## Appendix A- Record and Response to Submissions

Extracts from Government agency and authority submissions and submissions from the general public received in relation to SSD 17\_8351, and a response to each of these matters, has been outlined in the **Table below**.

Stage 2 SSD DA Shadow Study - South Tower: Hyde Park

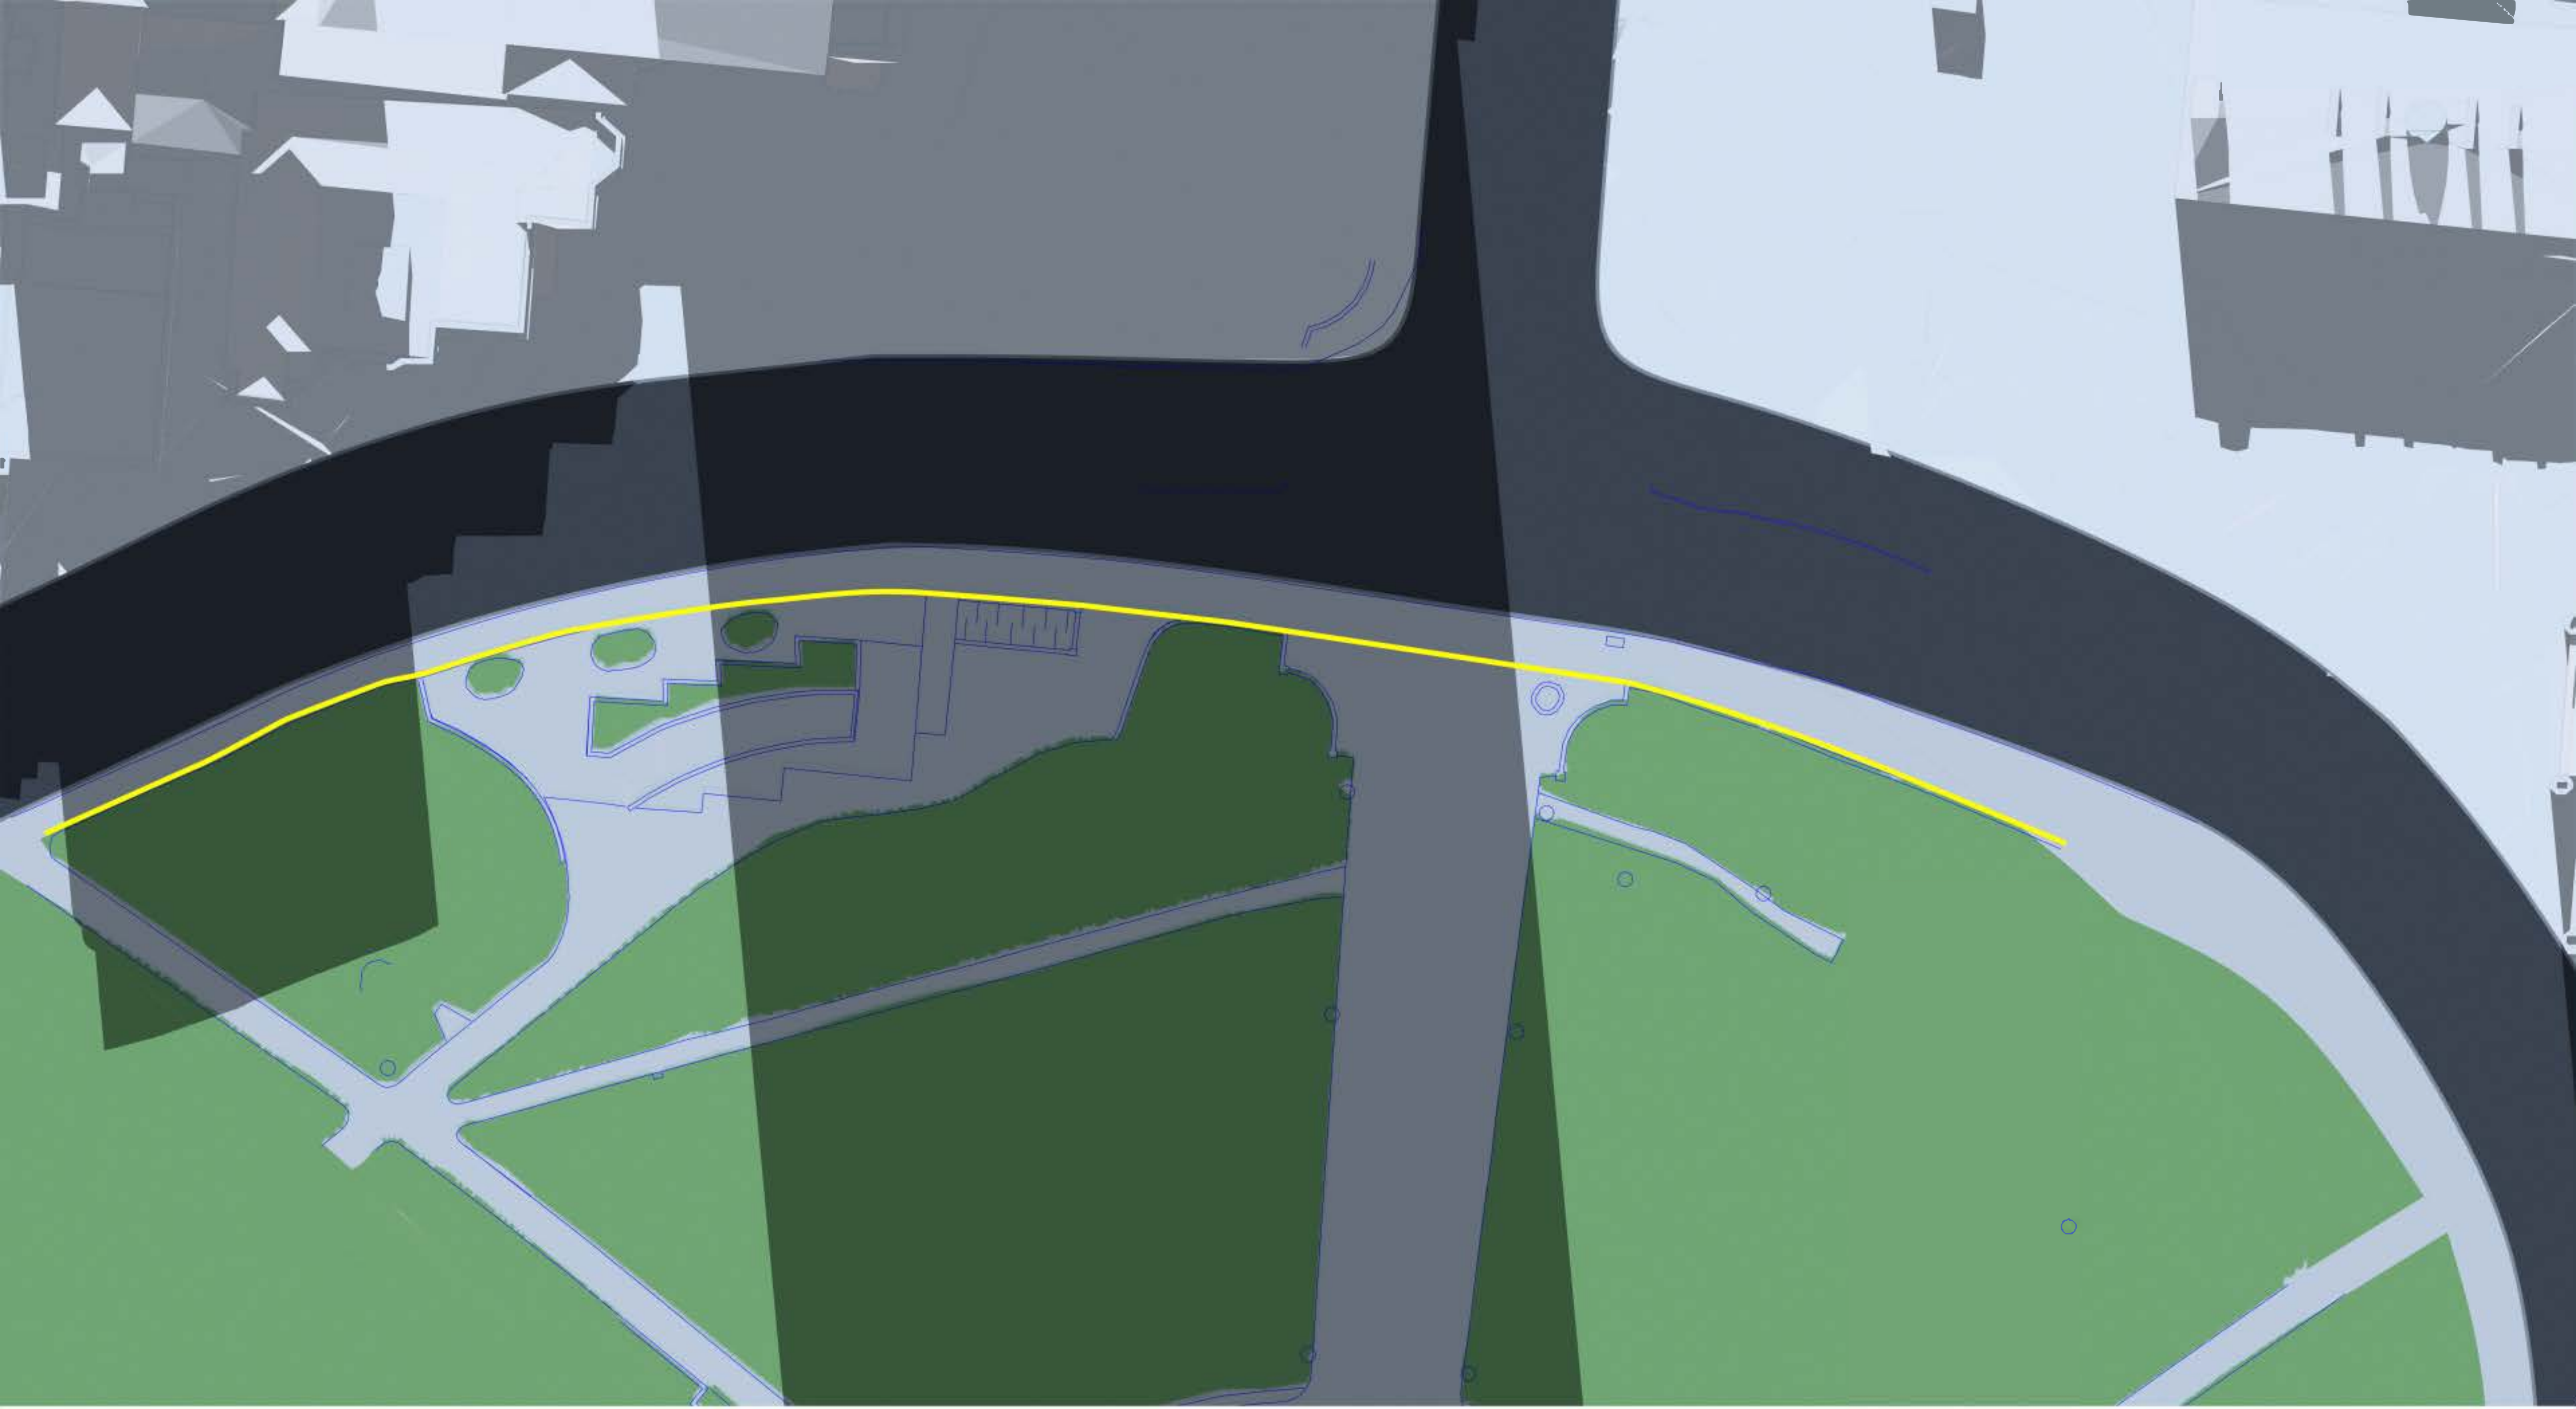
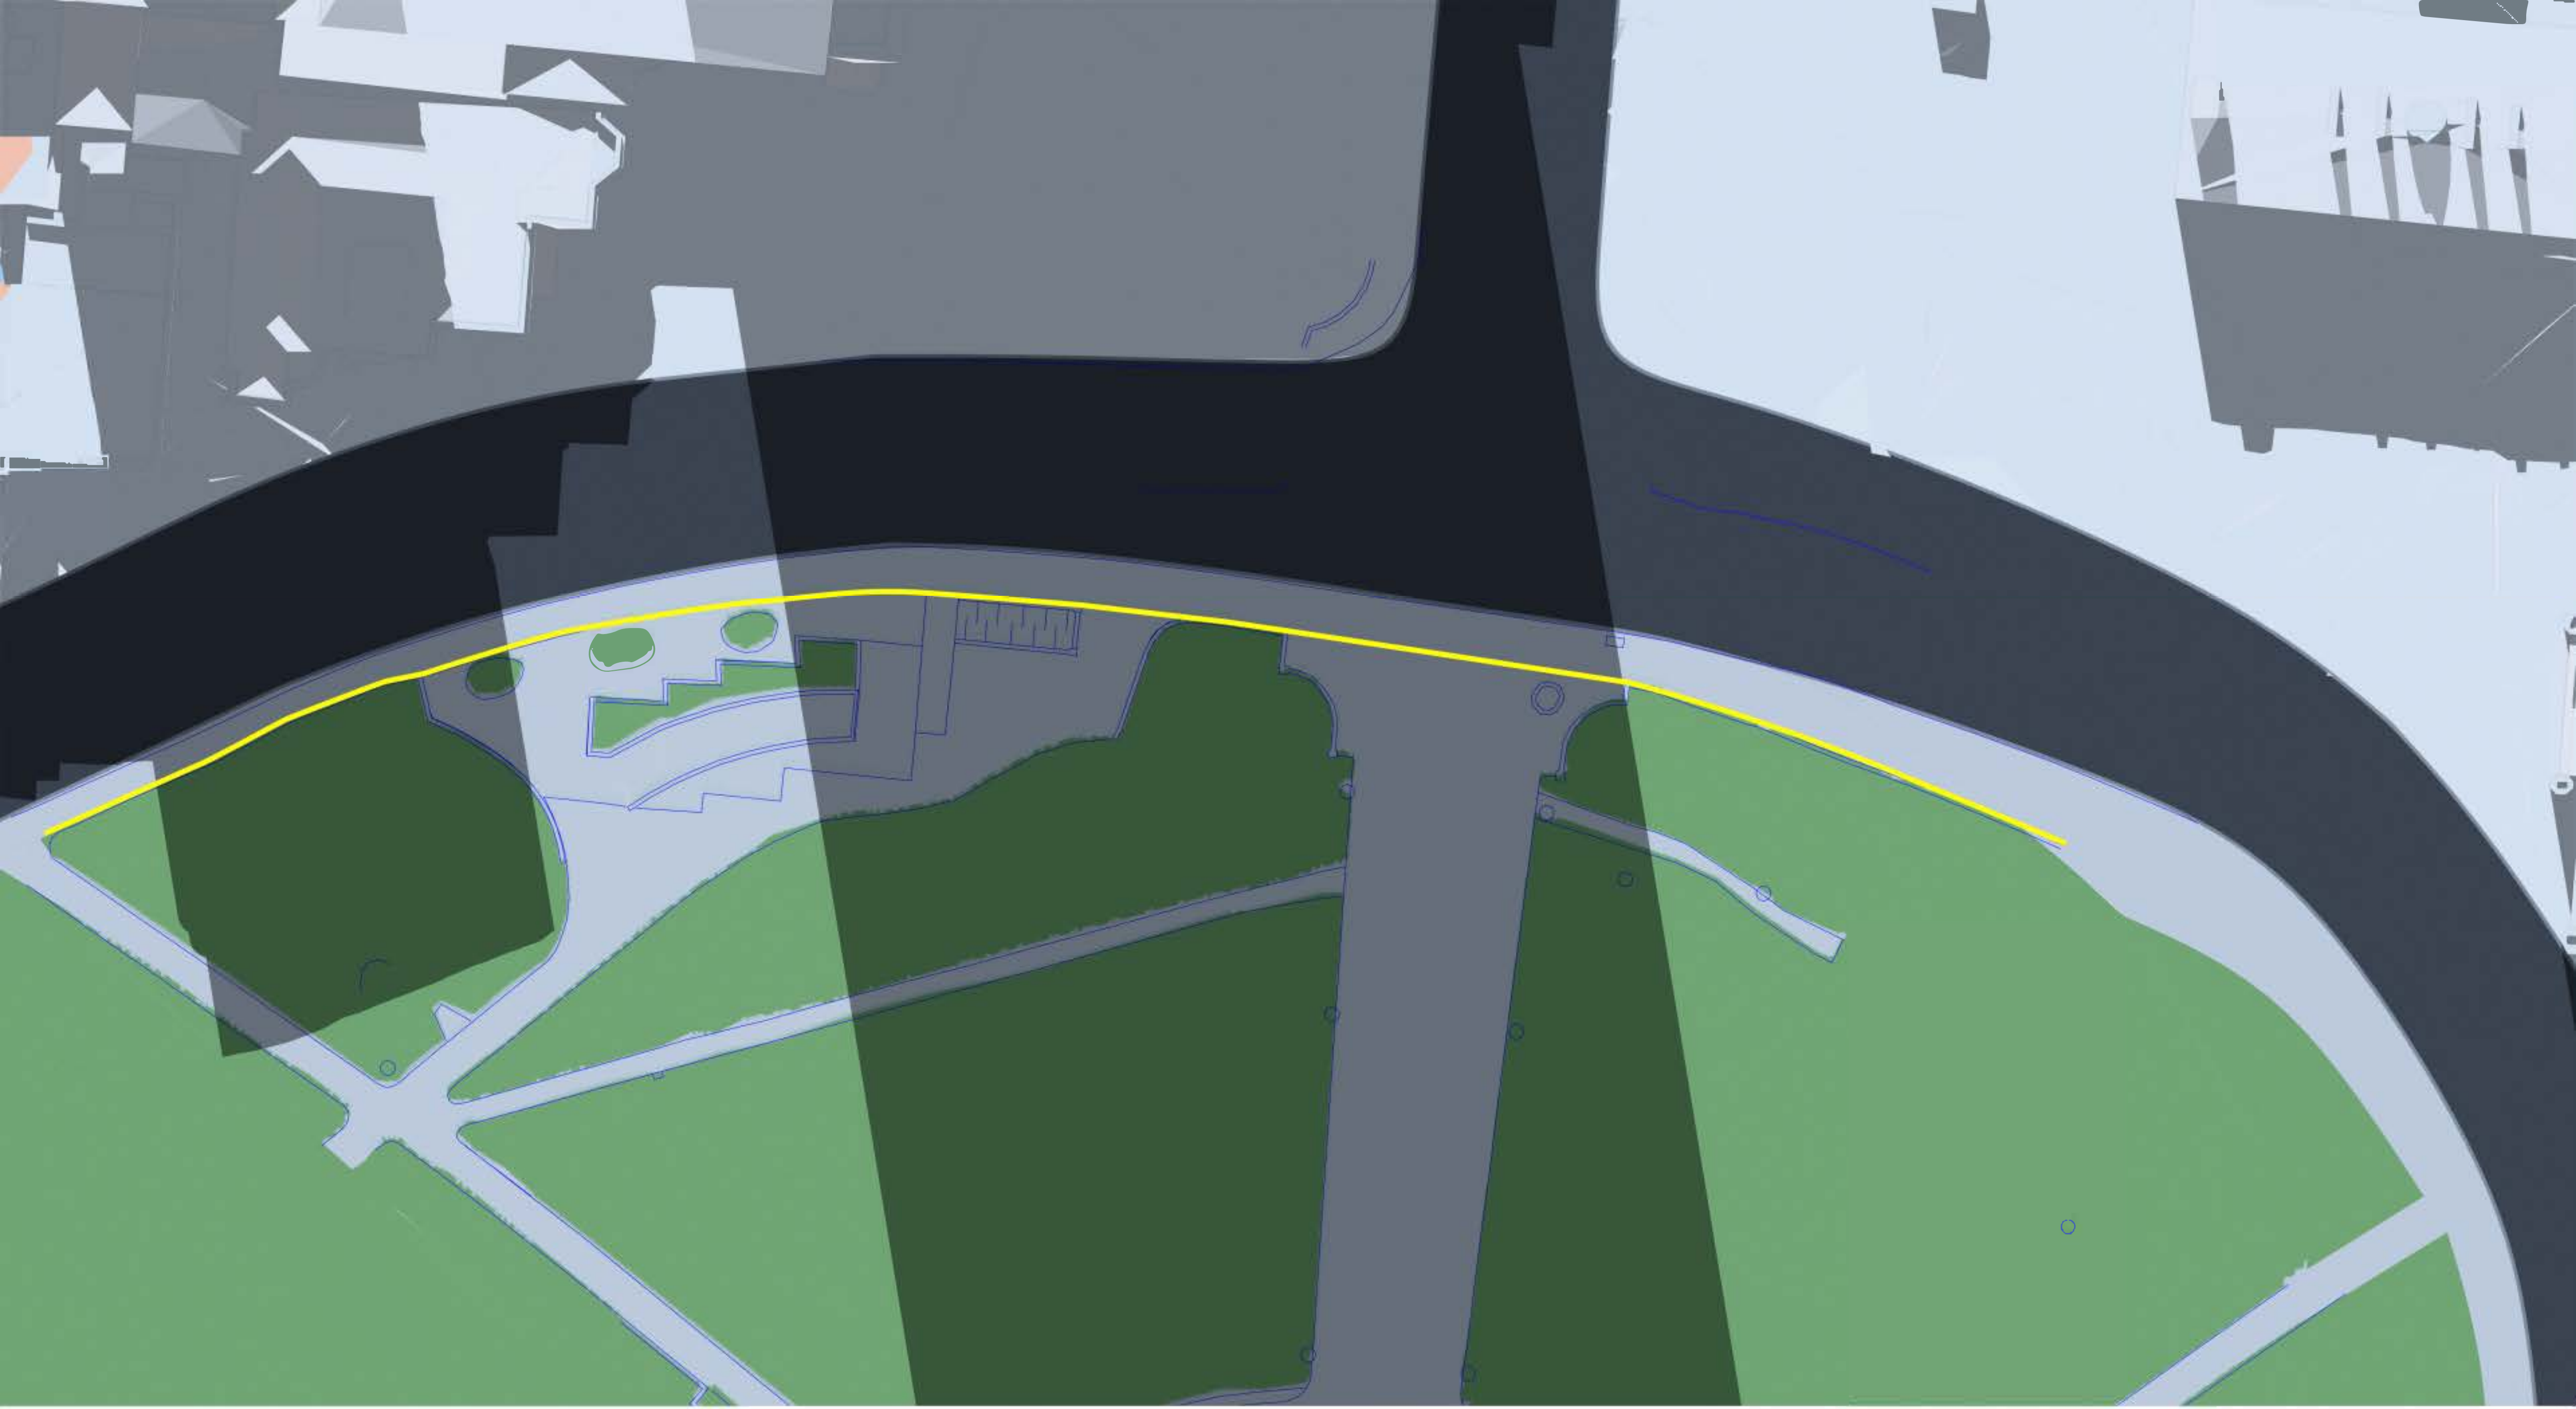
Review the impact of the proposal on solar access to Hyde Park in mid-winter, and how the proposal is consistent with the objectives within the SLEP 2012 to protect the amenity of public places. This should include an analysis of the overshadowing impacts on Hyde Park in comparison to a development which would apply the setbacks of SDCP 2012.	The revised overshadowing analysis at <b>Appendix C</b> confirms the relative impact of the proposed building envelopes when compared to a LEP/DCP compliant scheme. It demonstrates that in addition to the proposed envelopes being consistent with both the existing and potential future Sun Access Planes applying to the Site, these building envelopes will also not generate substantial or long-lasting shadows on Hyde Park consistent with the objectives and requirements of Cl. 6.16 of the Sydney LEP 2012. It is further demonstrated that minor overshadowing generated by the proposed envelopes is comparable to the compliant scheme, and as such are comparable to what would otherwise be expected under the controls as smaller, older buildings are replaced with new buildings designed to the City's height limits. The degree of additional shadow is also consistent with that which results from development in which the City of Sydney Council readily supports and approves (e.g. 148 King Street). Refer to the RTS for further discussion.
